From: Sue Howell
Sent: 12 December 2017 16:45
To: Claire Potts
Subject: FW: Planning Consultation on: BE/113/17/RES

APPLICATION **BE/113/17/RES**

Site Address: Land West of New Barn Lane Bersted

Approval of r
BE/113/17/RES
reserved matters following outline consent
BE/18/17/PL for appearance, landscaping, layout
& scale for a mix of up to 90No. residential units,
associated open space, landscaping, access &
car parking

SPECIFICATION
All works generally, to comply with the written Soft Landscape Specification.

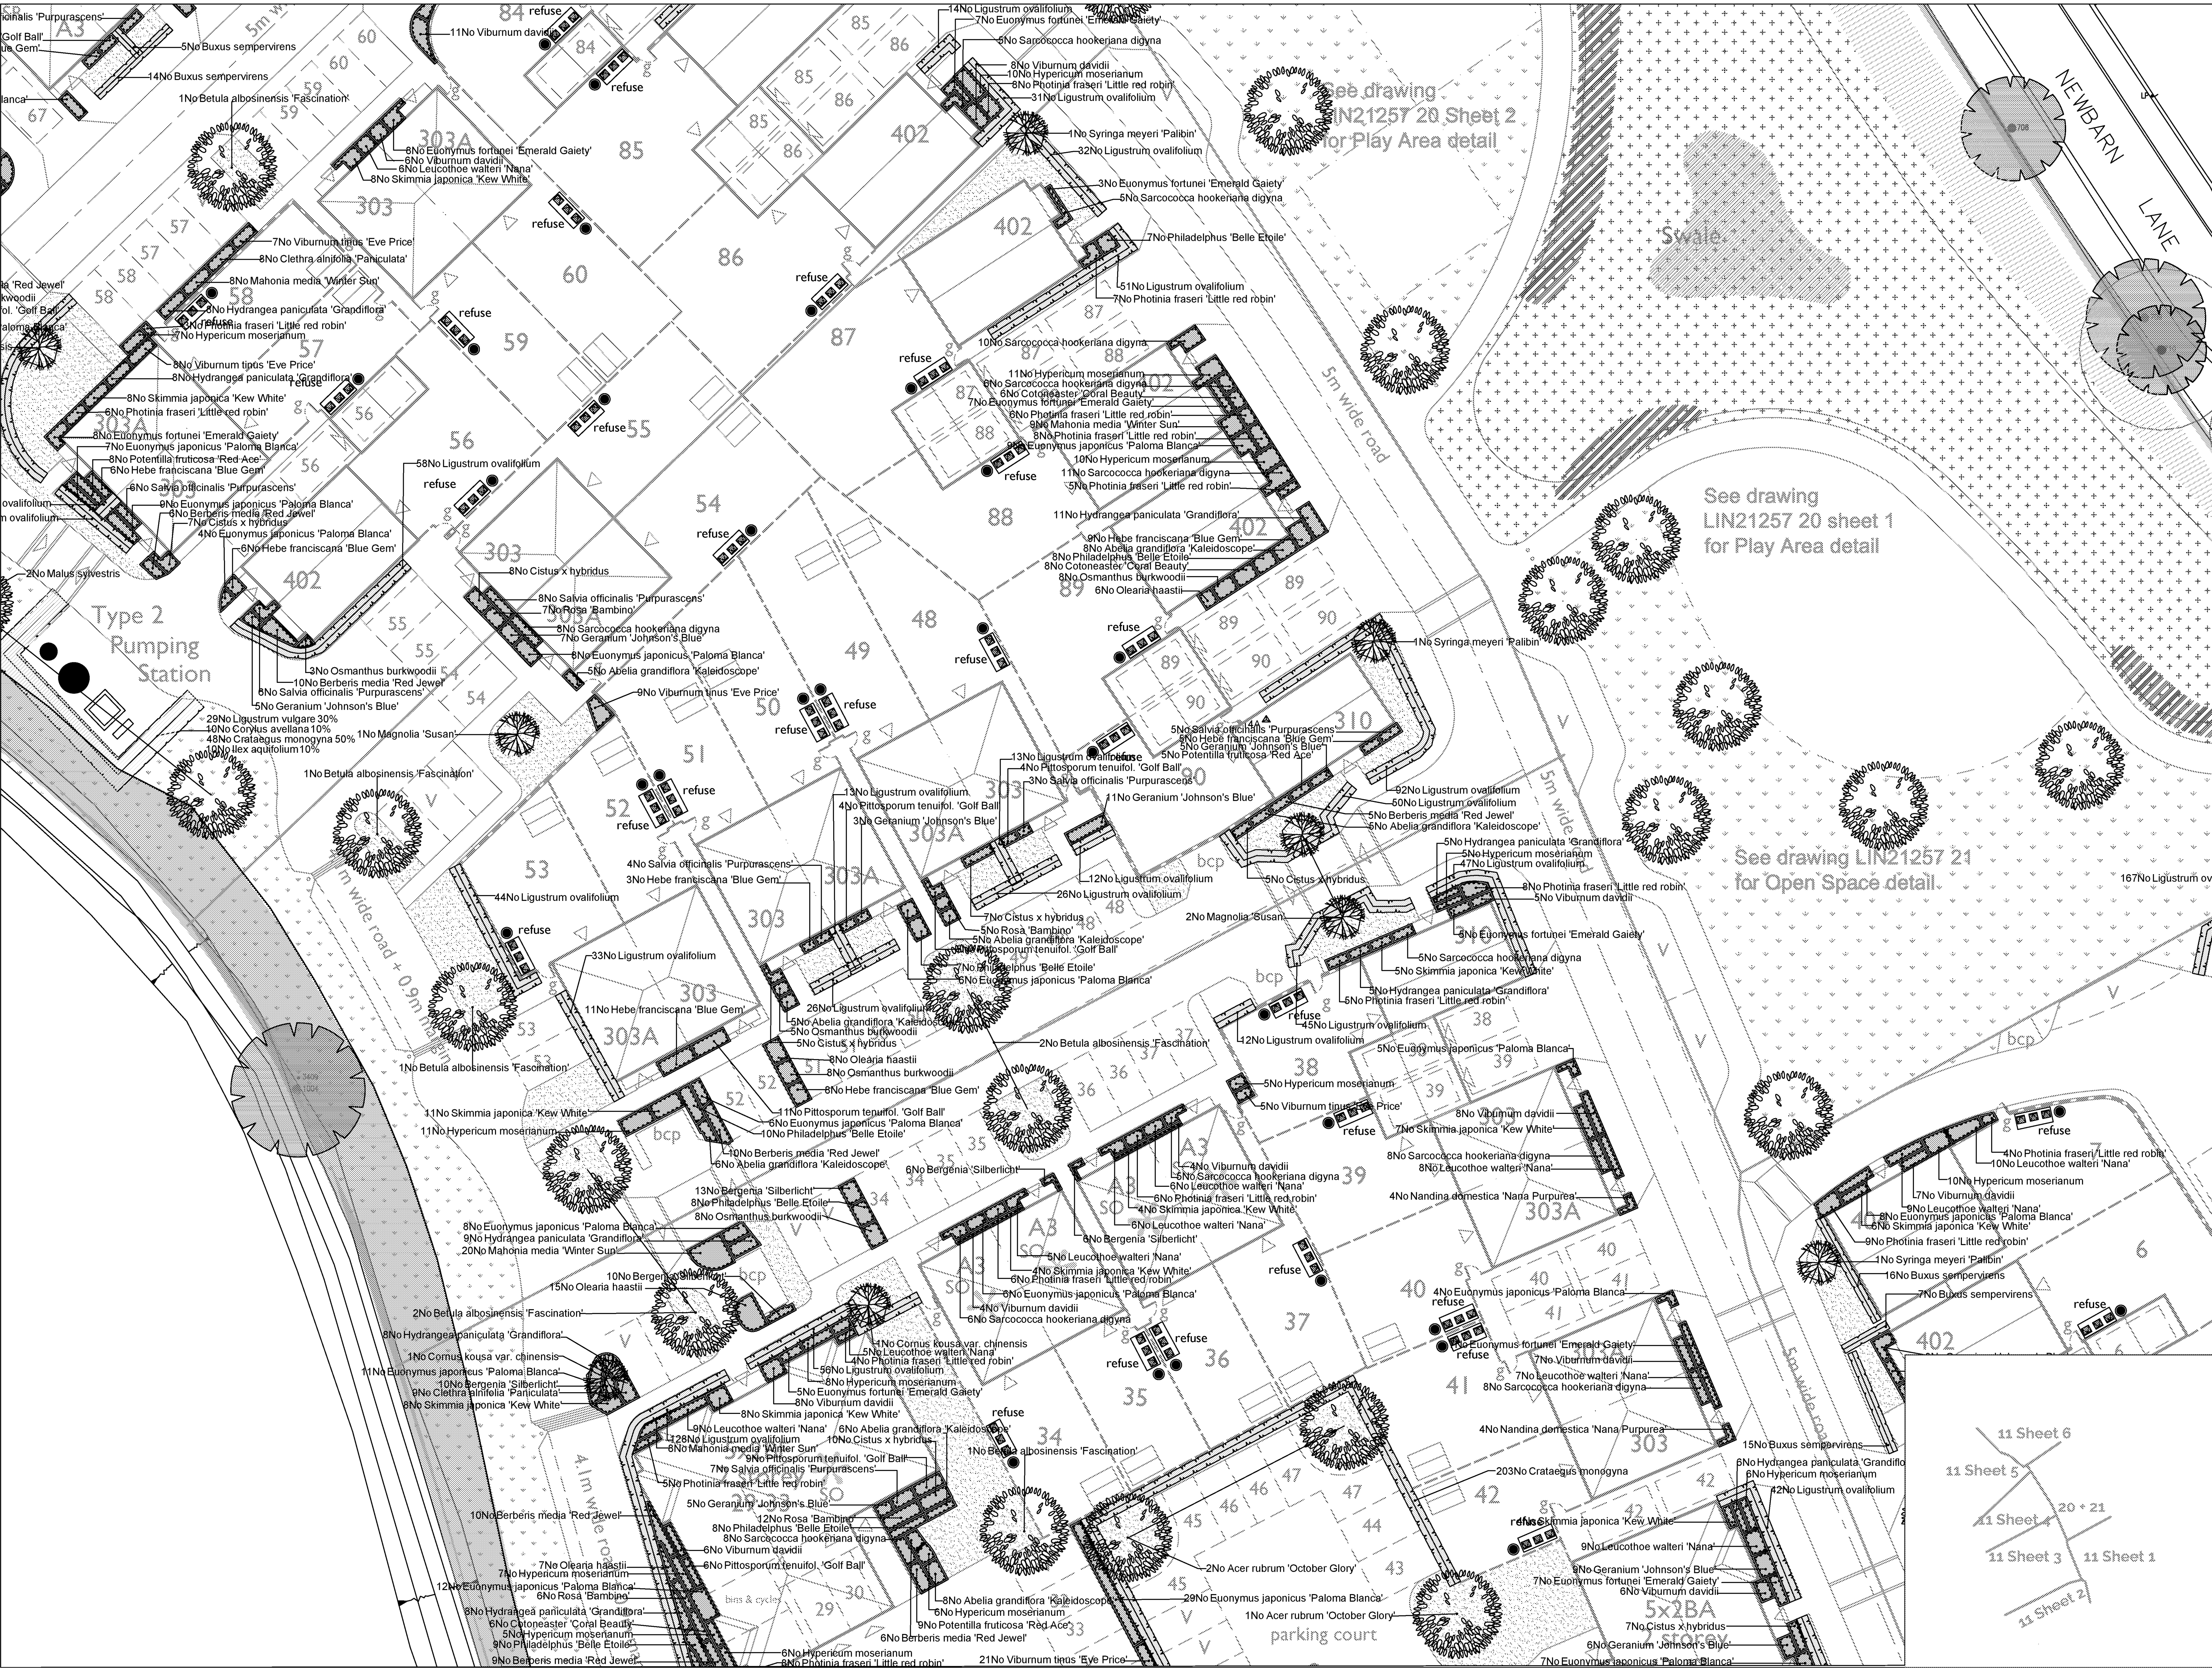
The play areas LEAP and 2 x LAP are now sited very closed to a detailed swale/water body. We would require clarification of the proximity of these to this drainage facility also to the depth of this indicated swale? The previously submitted detail indicated the main basin depth of 500mm, with 1000mm to the basin ditch only. The levels now shown would appear to indicate that this is now proposed to be significantly deeper than this with steeply angled sides? Please confirm the proposed levels of the swale, site sections sheet 2 16-1103-006 shows sections which stop short of this area, section E/E needs to extend through the play area and the proposed swale. Please also confirm the anticipated water holding period for this drainage facility?

The indicated play areas are also dissected now by the swale which is not desirable as these play open space areas would not have easy connectivity. RoSPA should be consulted regarding the suitability of the play spaces in relation to this potential standing water body.

- * Open space area proposed now significantly reduced by potential standing water body resulting in inadequate quantity of useable Public Open Space, confirmation of areas required.
- * Cross sections required to detail the proposed depth of swale and proximity to play areas.
